Date: 30-Jul-2025
Our Ref: 2025/91685

**TOWN AND COUNTRY PLANNING ACT 1990
TOWN AND COUNTRY PLANNING (GENERAL PERMITTED DEVELOPMENT) (ENGLAND)
ORDER 2015 – SCHEDULE 2, PART 1, CLASS A.1 (g)
AT: 24, Torridon Road, Dewsbury, WF12 7NX
Prior notification for single storey rear extension**

The proposal is for erection of single storey rear extension. The extension projects 6m beyond the rear wall of the original dwellinghouse. The maximum height of the extension is 4m, the height of the eaves of the extension is 3m

PROPOSED SITE PLAN

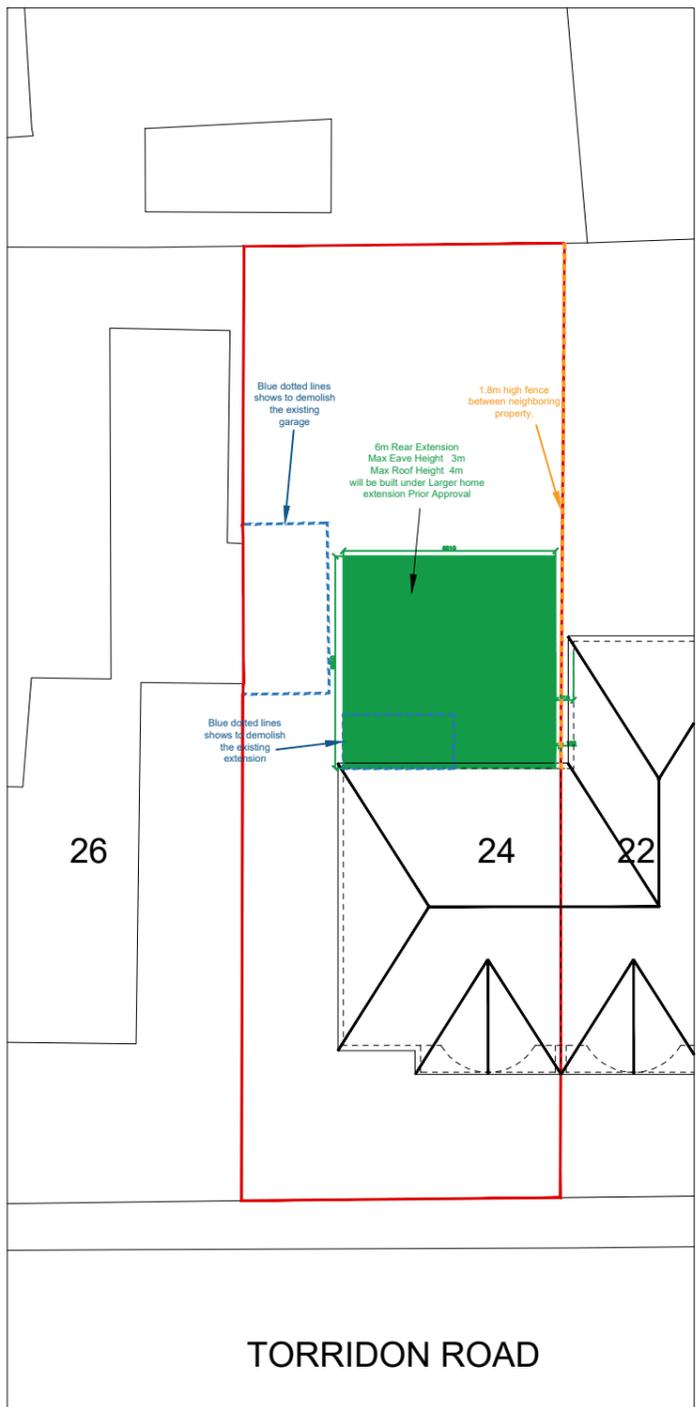
The proposed enlargement does not benefit from a general planning permission under Article 3(1) and Class A, Part 1 of Schedule 2 of the Town and Country Planning (General Permitted Development) (England) Order 2015 as the rear projection extends beyond a wall forming a side wall of the original dwellinghouse and has a width greater than half the width of the original dwellinghouse contrary to sub-paragraph A.1(j) of Class A.
